CITY OF ALBUQUERQUE

Re: 1st Nations Community Health Source

5608 Zuni RD SE

Traffic Circulation Layout

SHEET TITLE  
**ARCHITECTURAL  
SITE PLAN FOR  
TRAFFIC CIRCULATION  
LAYOUT**

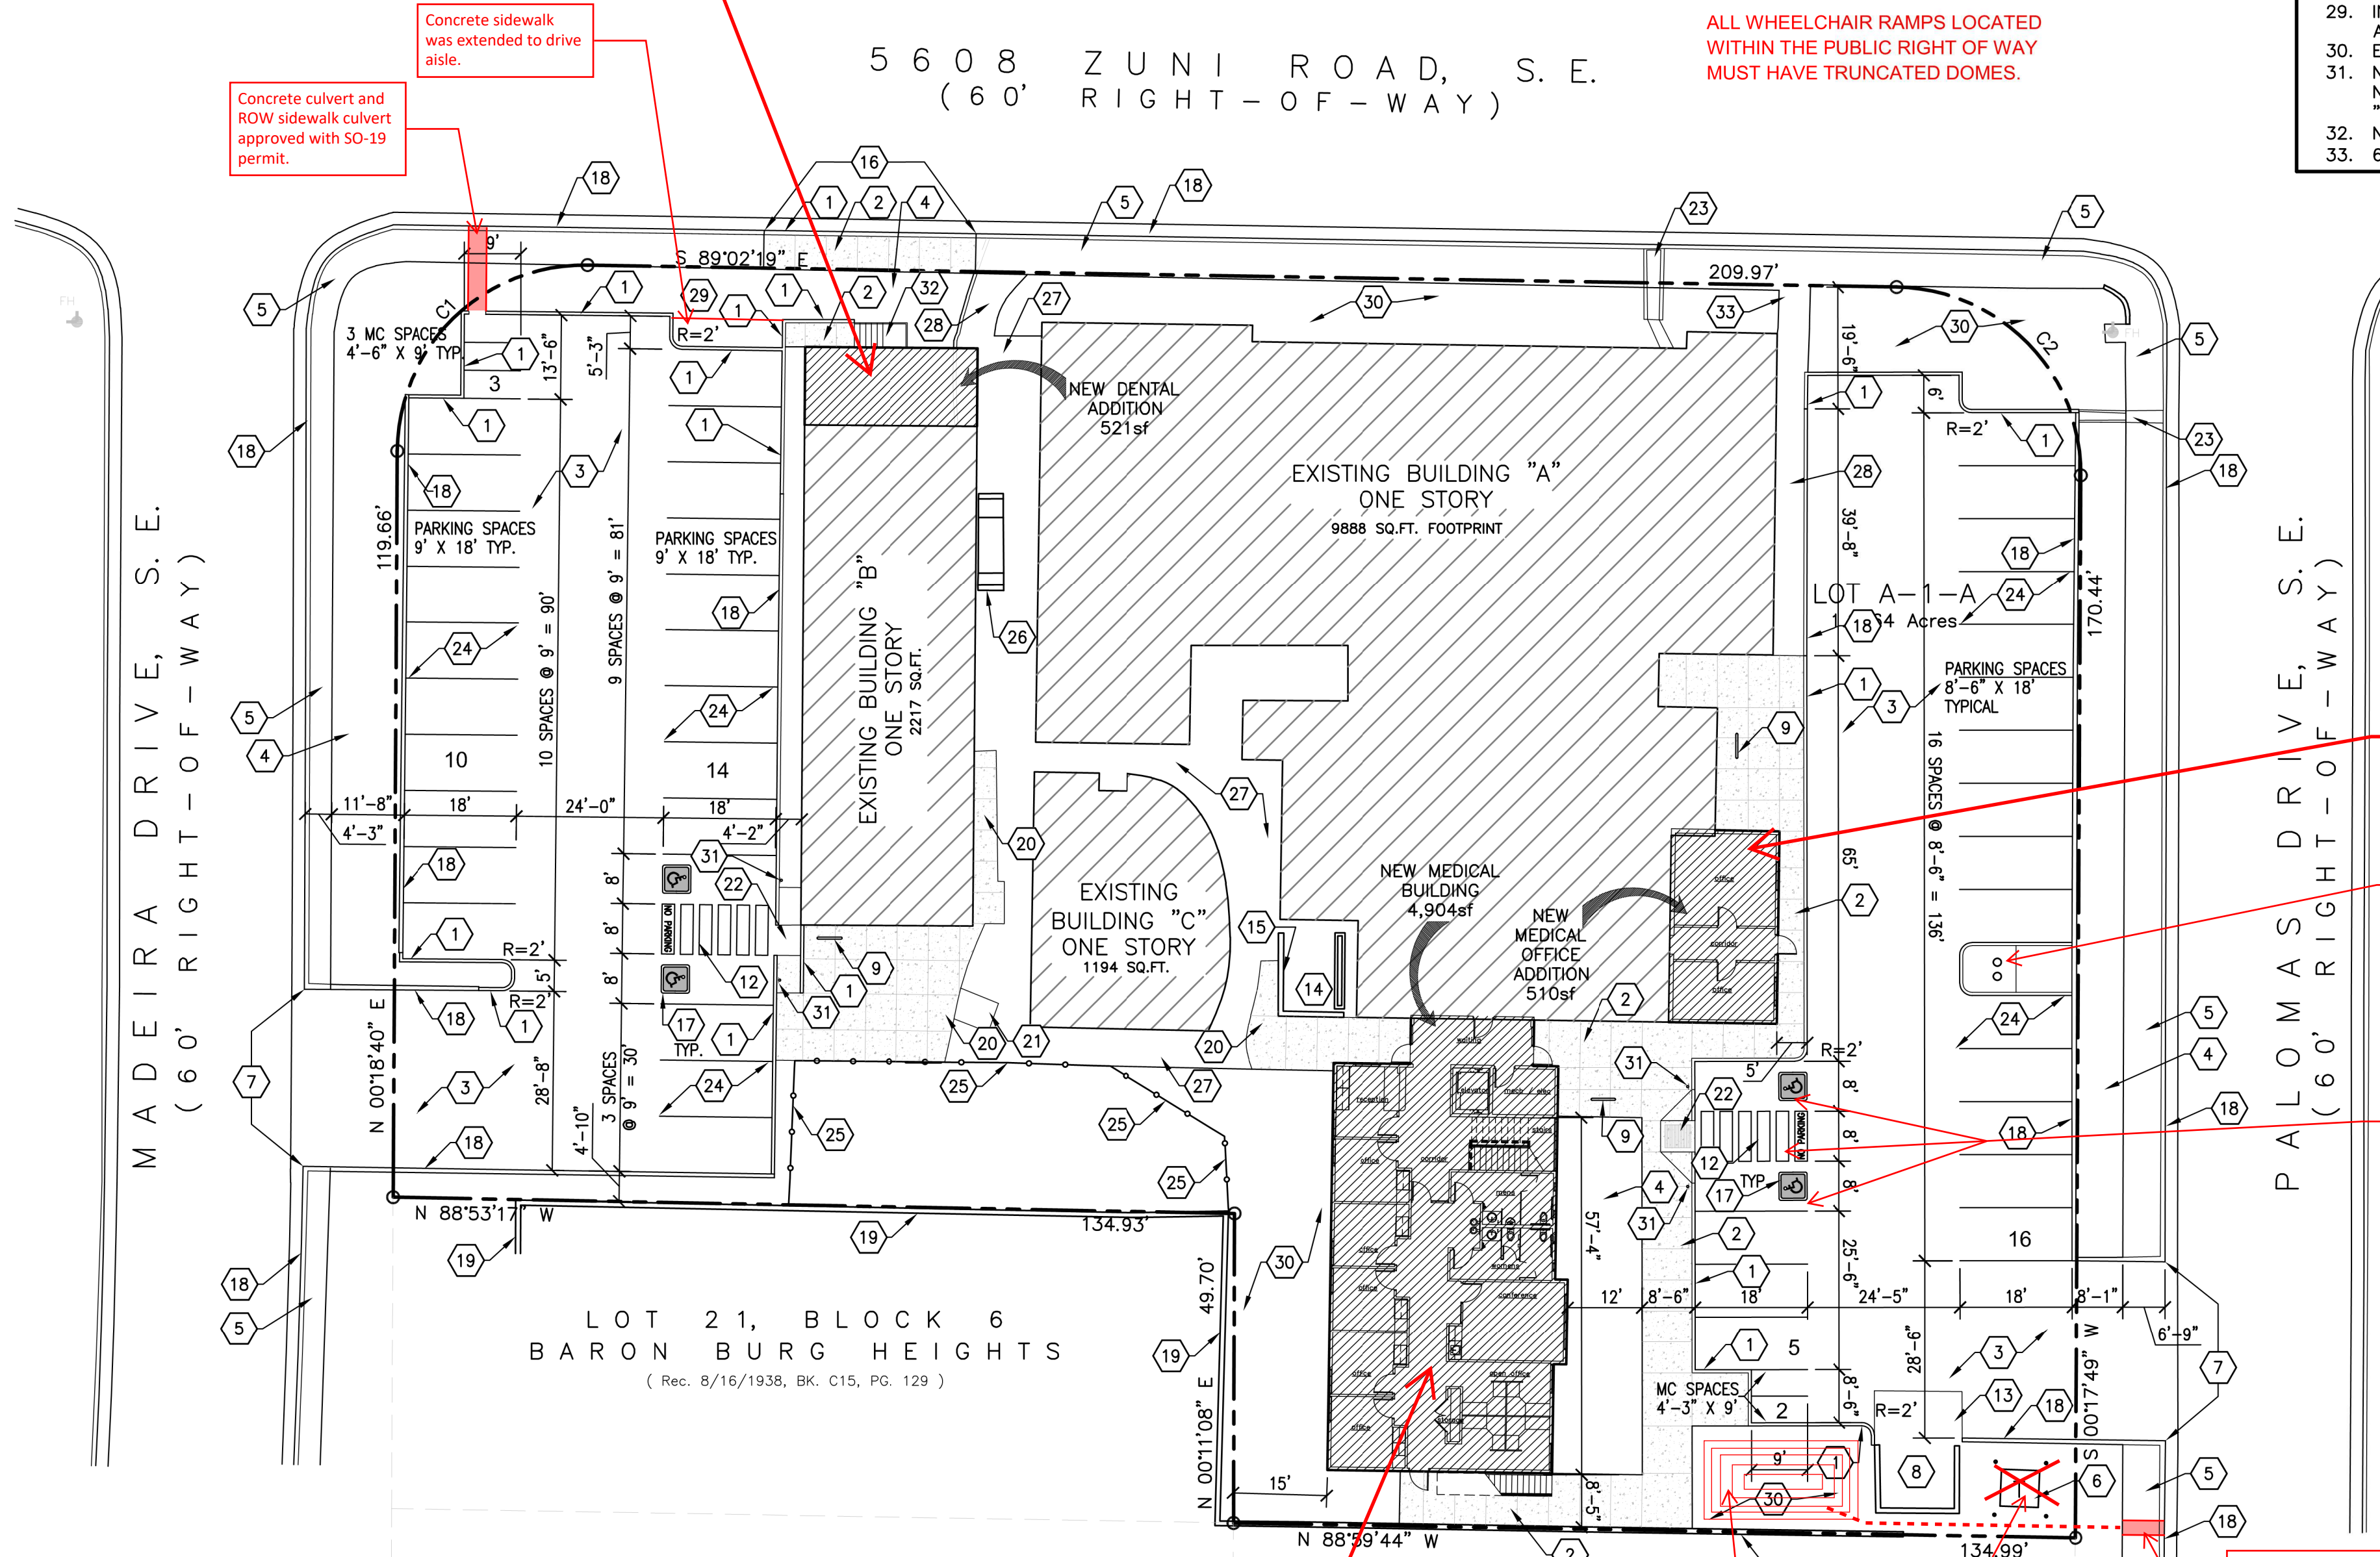
- 1. The traffic circulation layout must be stamped, signed, and dated by an engineer or architect licensed in the state of New Mexico.
- The ADA accessible parking sign must have the required language per 66-7-352.4C NMSA 1978 "Violators Are Subject to a Fine and/or Towing." Please call out detail and location of HC signs.

- 3. The ADA access aisles shall have the words "NO PARKING" in capital letters, each of which shall be at least one foot high and at least two inches wide, placed at the rear of the parking space so as to be close to where an adjacent vehicle's rear tire would be placed. (66-1-4.1.B NMSA 1978)

- 4. The ADA parking space has a clearly visible, blue, International Symbol of Accessibility painted on the pavement at rear of the space (66-1-4.1.E NMSA 1978) or MUTCD recommends a white symbol on a blue background.

- 5. Please specify the City Standard Drawing Number when applicable. Use Standard curb and gutter 2415A to close the driveway.
- 6. On-Street parking credit to fulfill zoning's parking requirement must be requested and approved by the Traffic Engineer, Racquel Michel prior to TCL approval. The application requires at least 45 working days. On-street parking credit is based on available parking along public right-of-ways fronting the property. The business will only be granted 50% credit for available street parking.
